From: Iqraa Malik
Sent: 15 July 2020 10:42
To: Sian Eggington
Subject: FW: Request for further information Y/58/20/HH
Attachments: We sent you safe versions of your files; Site Location.pdf; Proposed.pdf

The plans you've submitted are for a different application. The site address for this application is Rosemary Cottage, Bilsham Road.

Proposed Extensions Plans and Elevations Planning
Date June 2020
Scale 1:200 1:1250

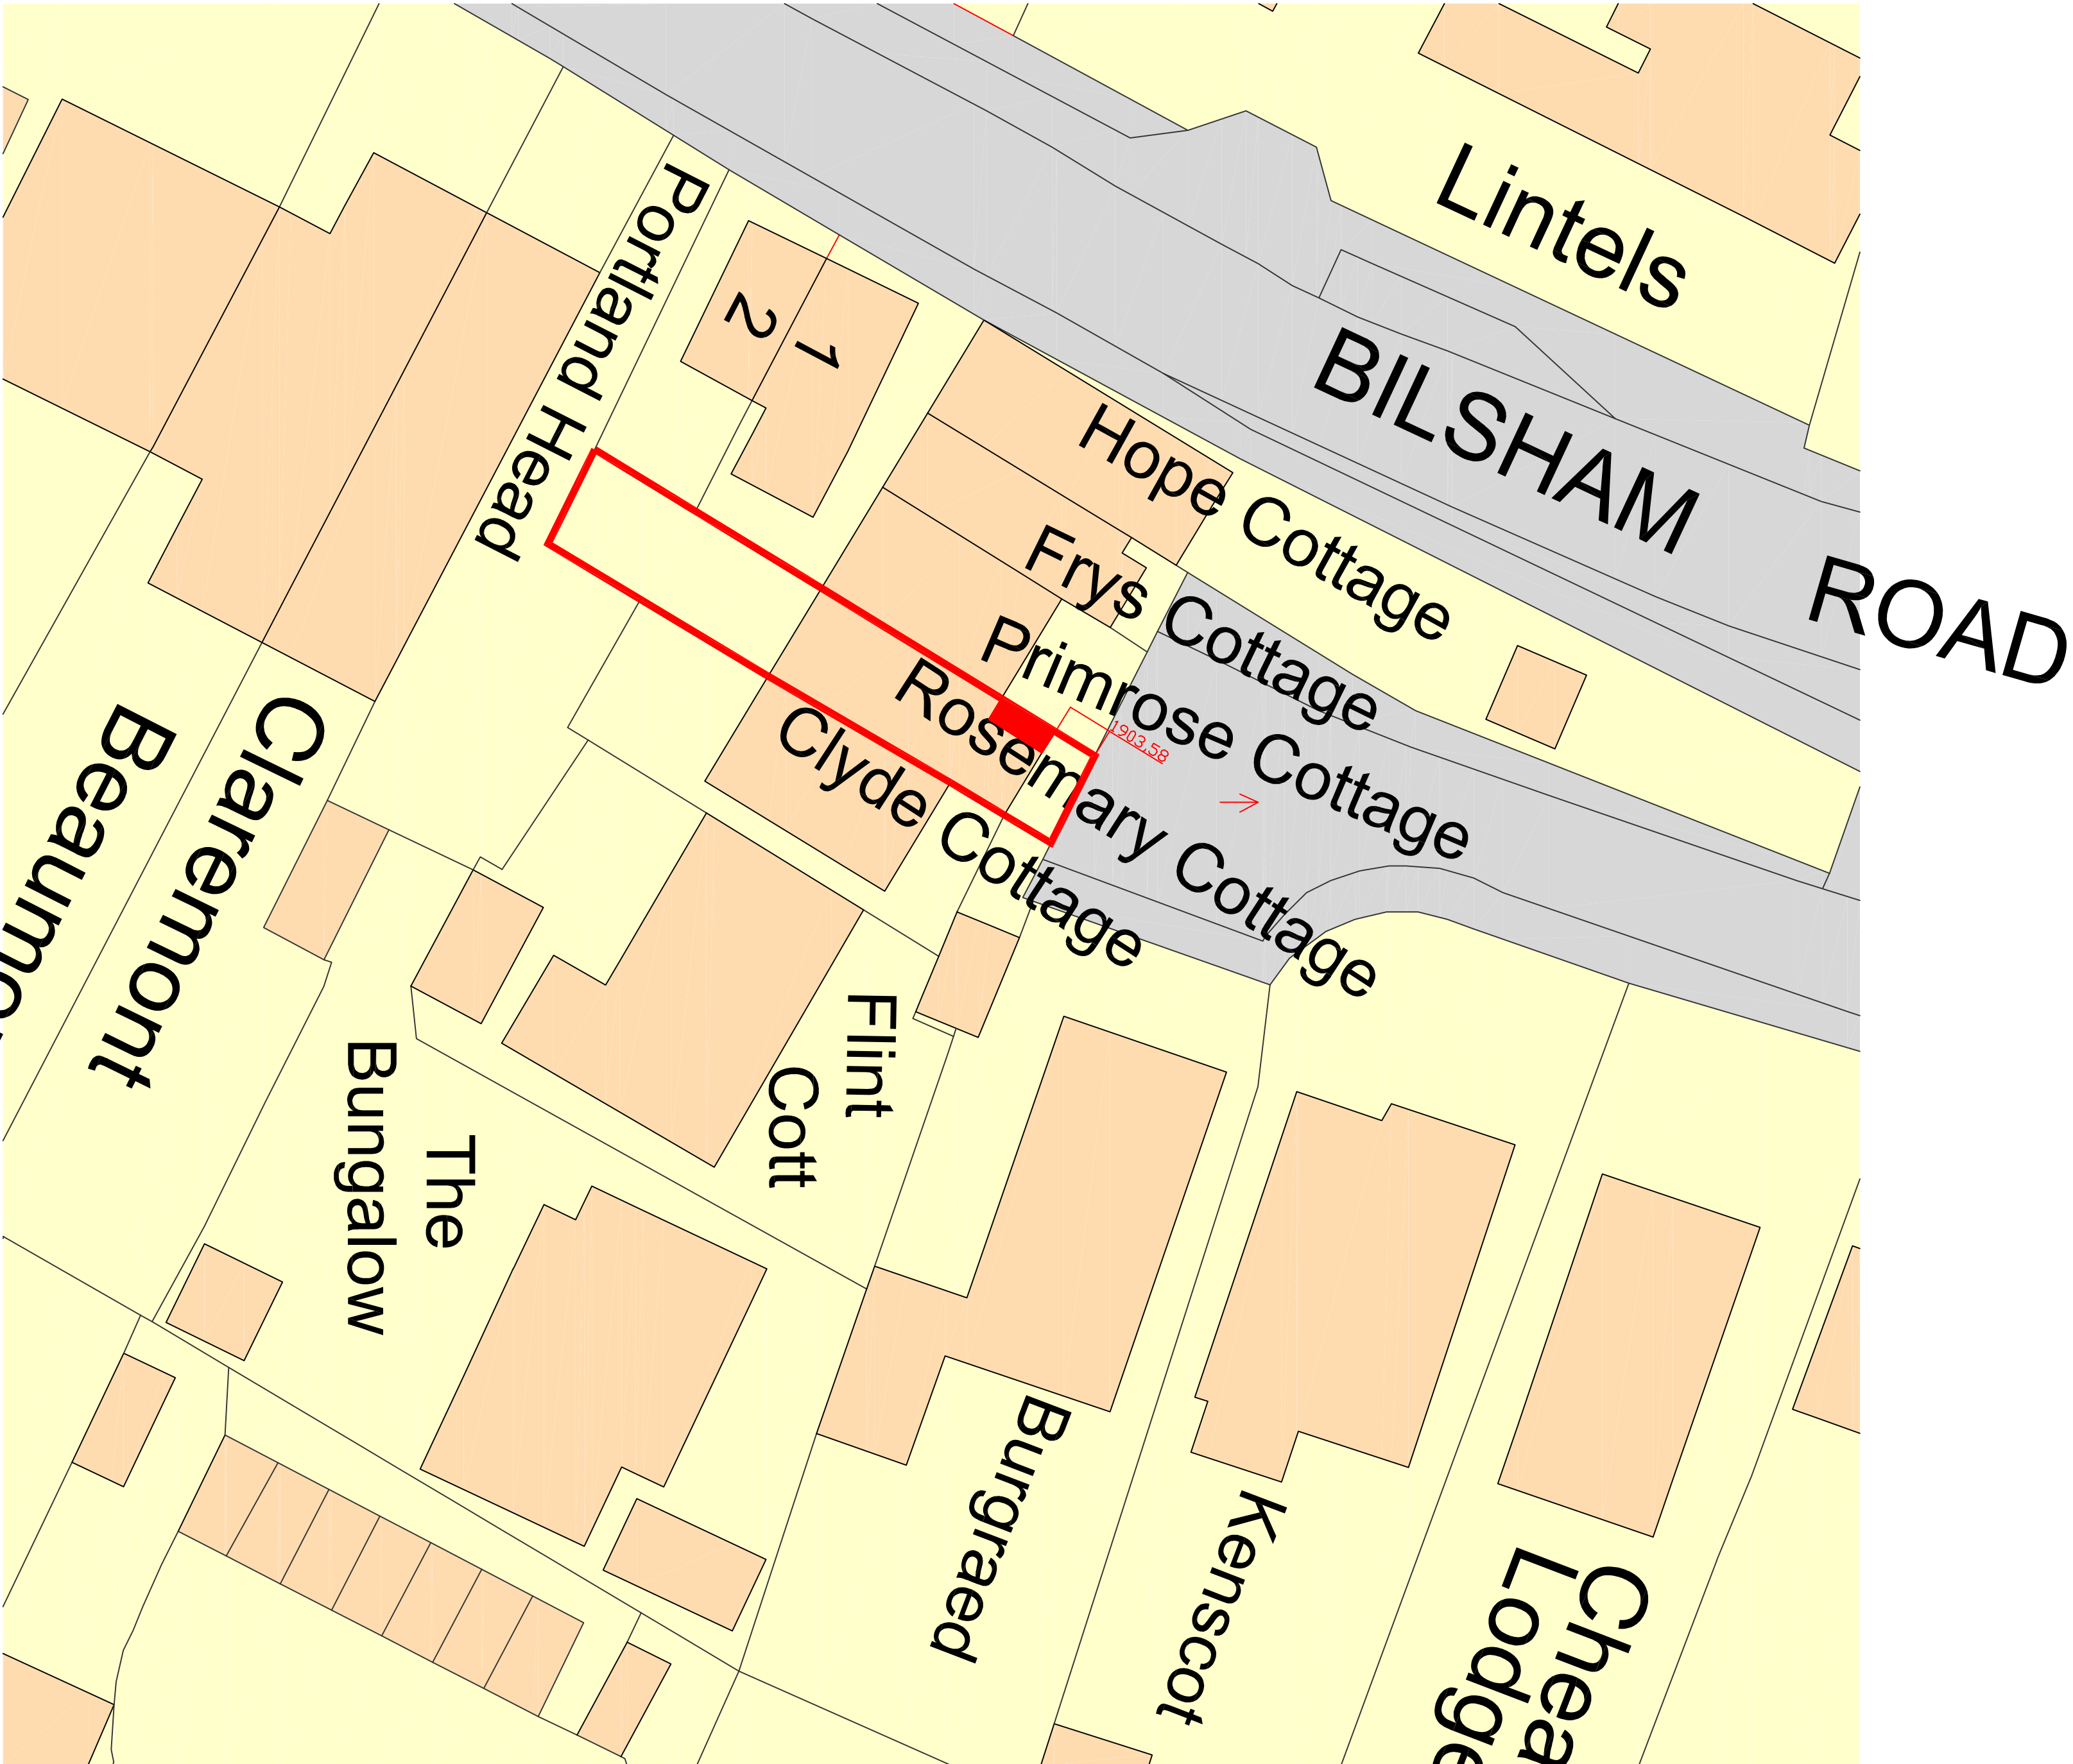
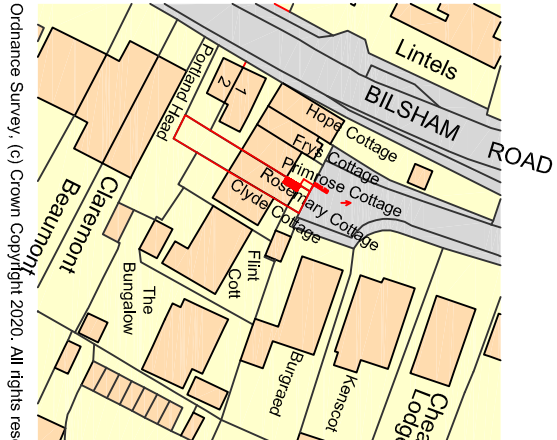
Please submit your Block Plan to include dimensions from the proposed extensions to all site boundaries. Along with this, please include a scale bar on all your plans.
